Natural England's Risk and Issues Log - Deadline 1 Submission.

The construction and operation of the Sheringham Shoal Extension and Dudgeon Extension Offshore Wind Farms located approximately 16km and 27km respectively from the Norfolk Coast in the Southern North Sea.

Planning Inspectorate Reference EN010109

20th February 2023

Figure 1 The proposed initial 1km² (light blue polygon) native oyster restoration site search area and the indicative size of the 10,000m² restored reef (red square within blue polygon) in the north-western section of the CSCB MCZ

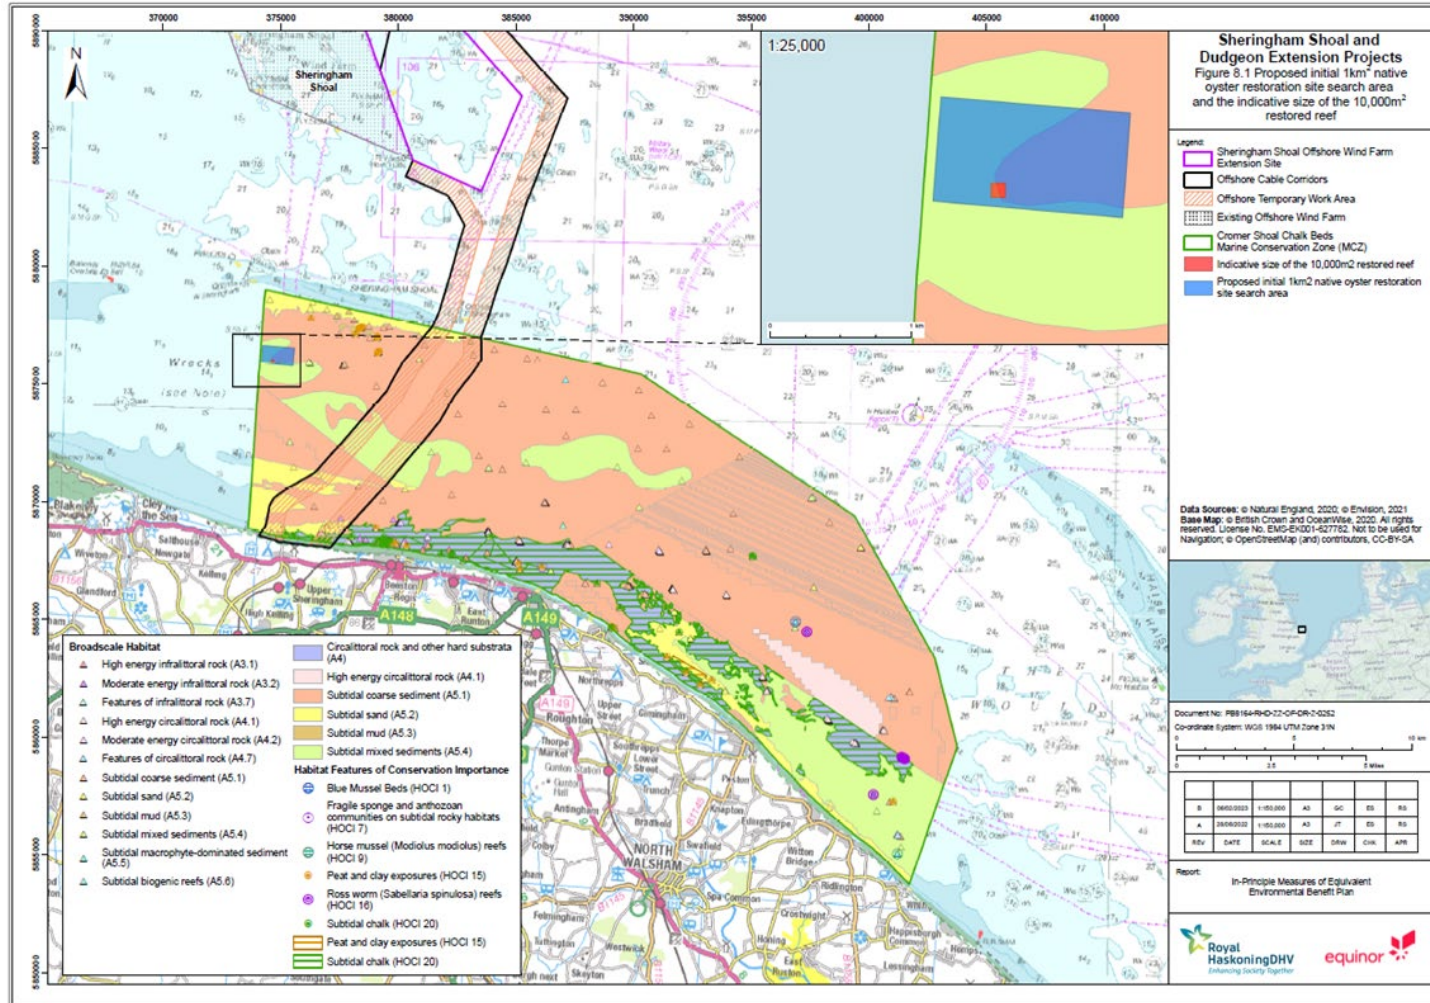
Document Used: (APP-081) 6.4 Appendix 4 - Assessment of Potential Impacts on Cromer Shoal Chalk Beds Marine Conservation Zone Features from Planting of Native Oyster Beds									
G23	20, 21, 22, 23	Natural England advises that the area behind the MREB option is sound i.e. the restoration of mixed sediment/reef softness communities in a new location. Natural England highlights the importance of the existing mixed sediment within the Cromer Shoal MCZ. The Cromer Shoal MCZ mixed sediment in this location has several sub features to that of the generic habitat type and there is no current requirement to restore/enhance these habitats. Natural England therefore advises against the placement of cluth and restoration of an Oyster bed in the middle of a mixed sediment area. For this to be considered as additionally we advise that it would be better to extend/enhance the area of the mixed sediment on the boundary with impoverished coarse sediment e.g. in the centre of the 'L' shaped mixed sediment area or north/south of the site rectangle.
